CITY OF PORTLAND

BUILDING PERMIT

Located At 721 STEVENS AVE

has permission to Construct 2nd means of egress

R-5 zone

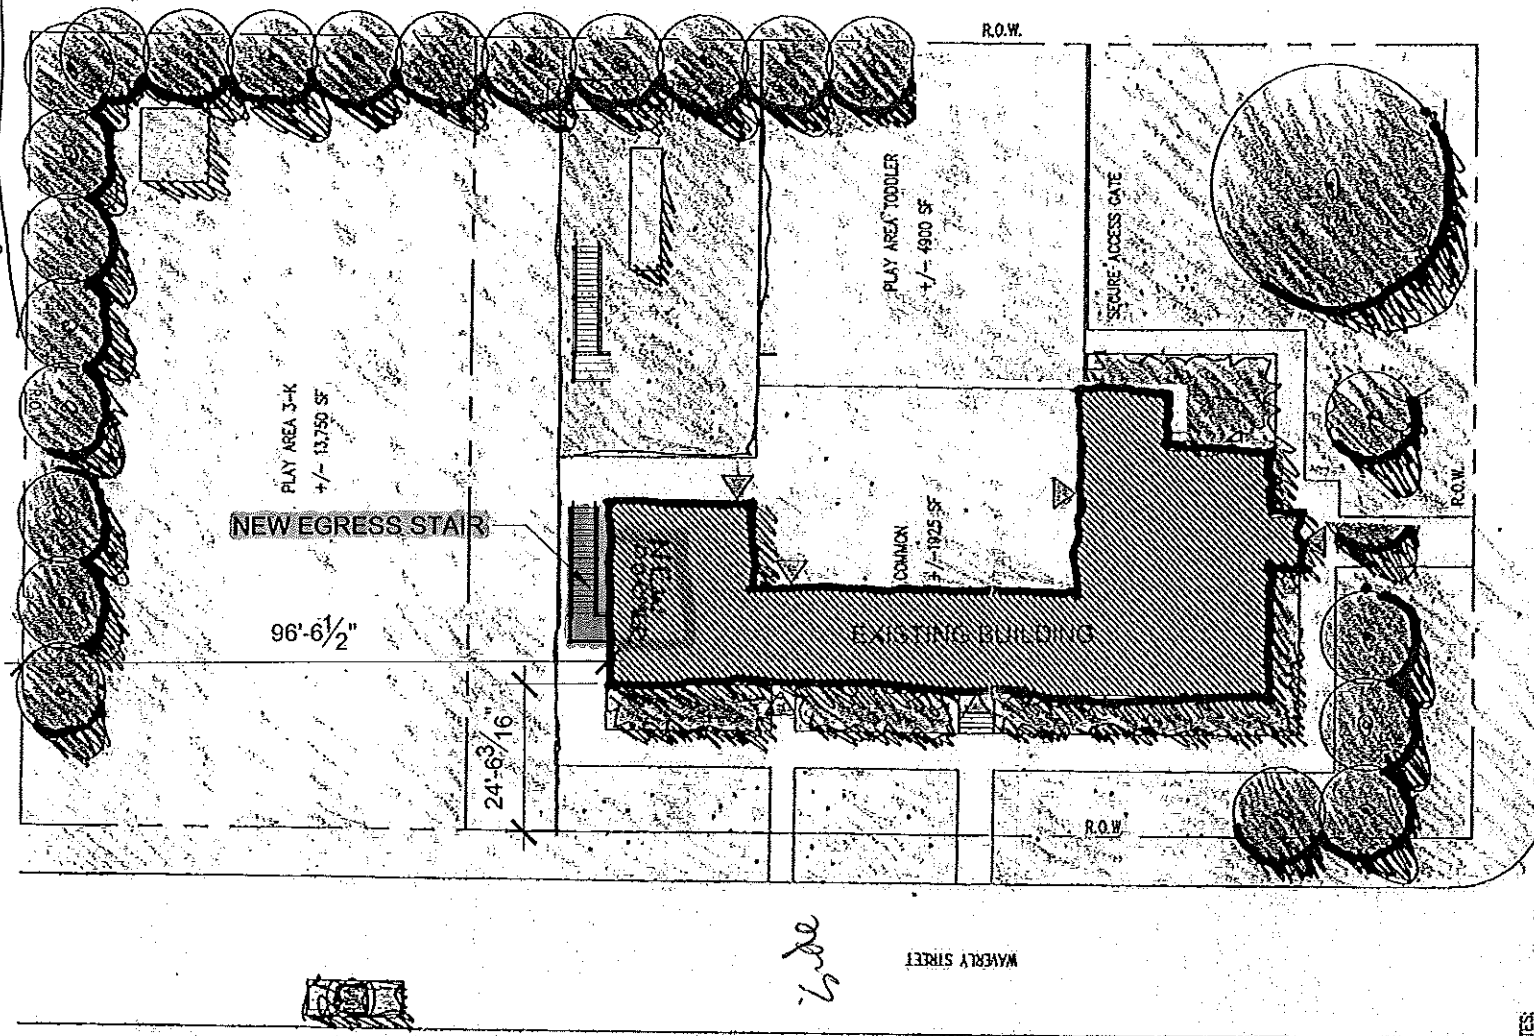
notes: Prot the stairway be enclosed under dry cover - has site plan exempt.

2 Dormer Framing Plan
 SCALE: 1/4" = 1'-0"

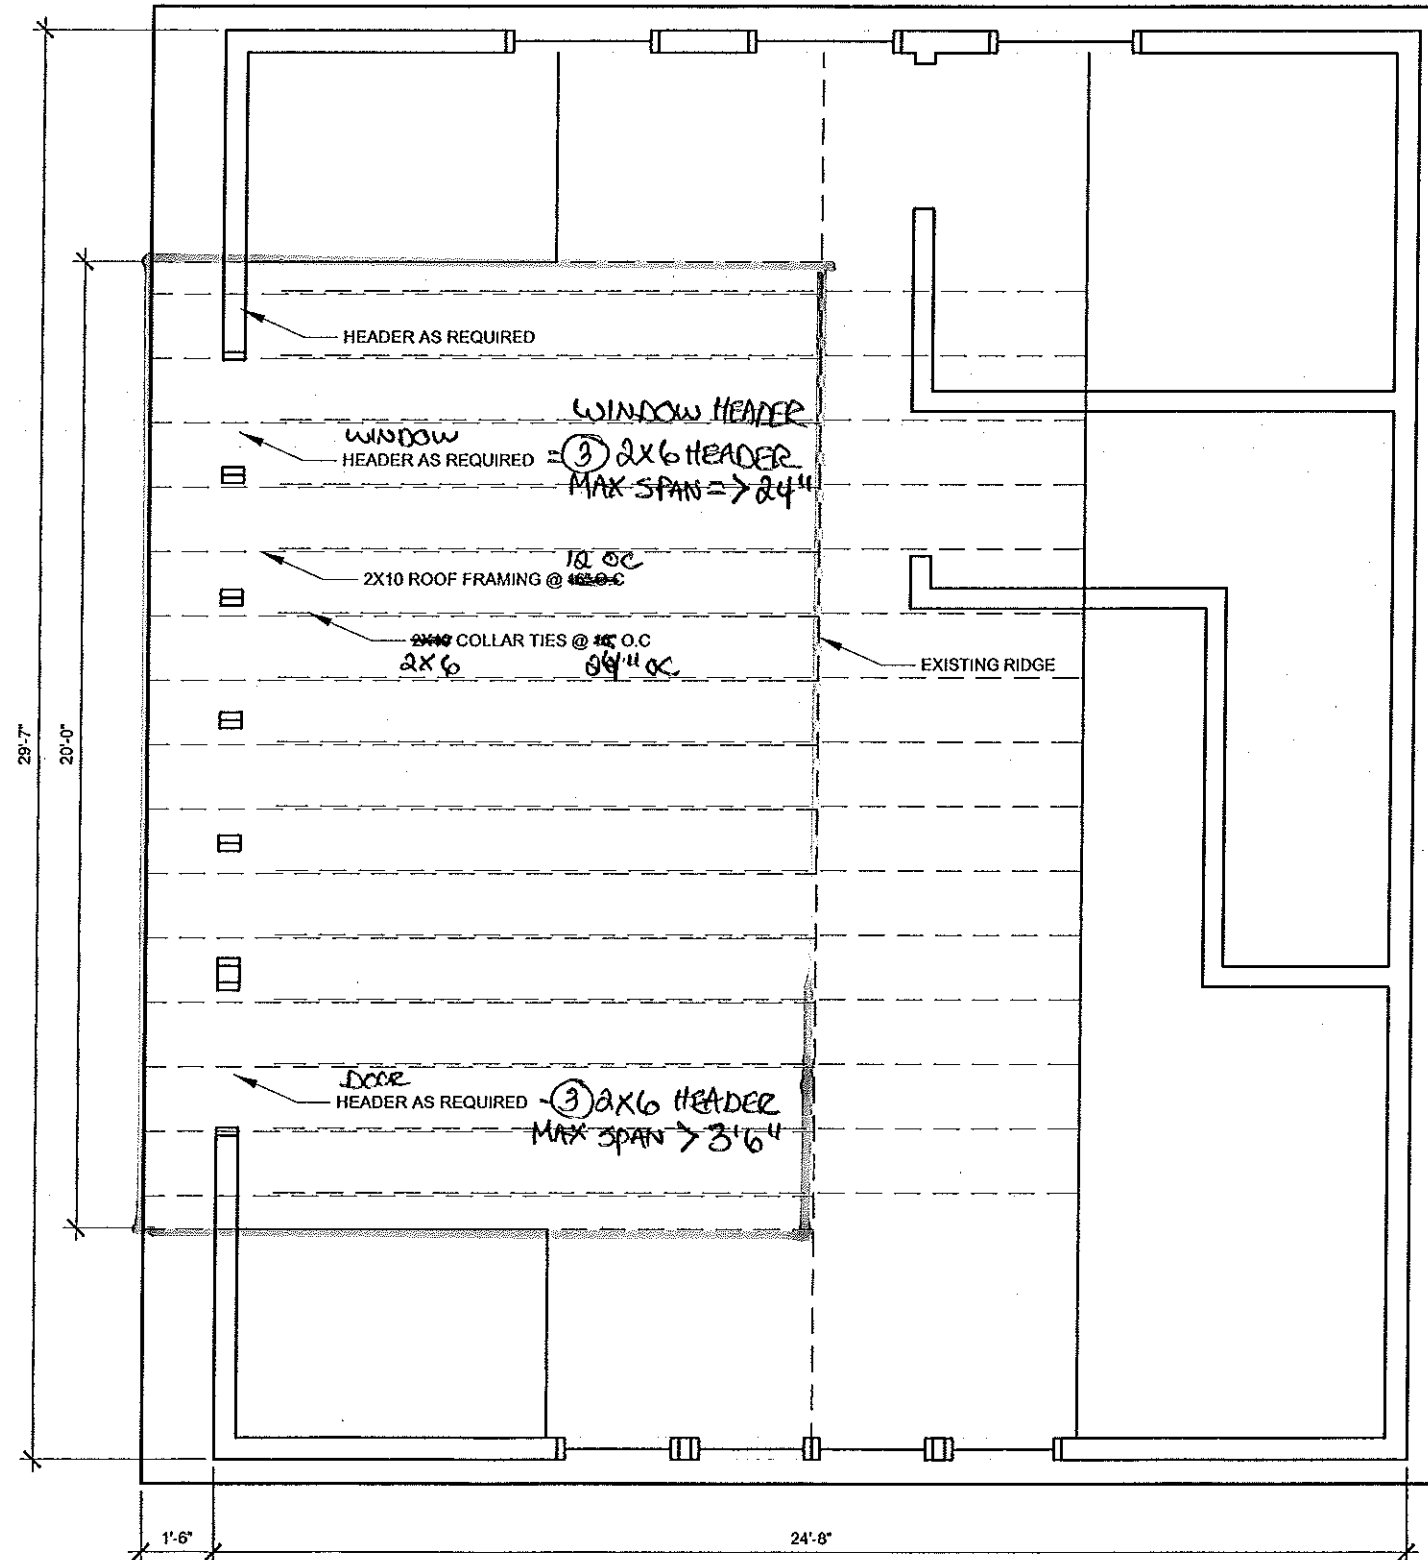
1. Separate permits are required for any electrical, plumbing, sprinkler, fire alarm HVAC systems, heating appliances, commercial hood exhaust systems and fuel tanks. Separate plans may need to be submitted for approval as a part of this process.
2. Application approval based upon information provided by the applicant or design professional. Any deviation from approved plans requires separate review and approval prior to work.
3. Guards must be 42 inches in height with openings less than 4 inches. Graspable rails must be installed on both sides of the stair guard at 34" to 38".
4. **The dormer rafters must be 2" x 12"-s 12" oc.**
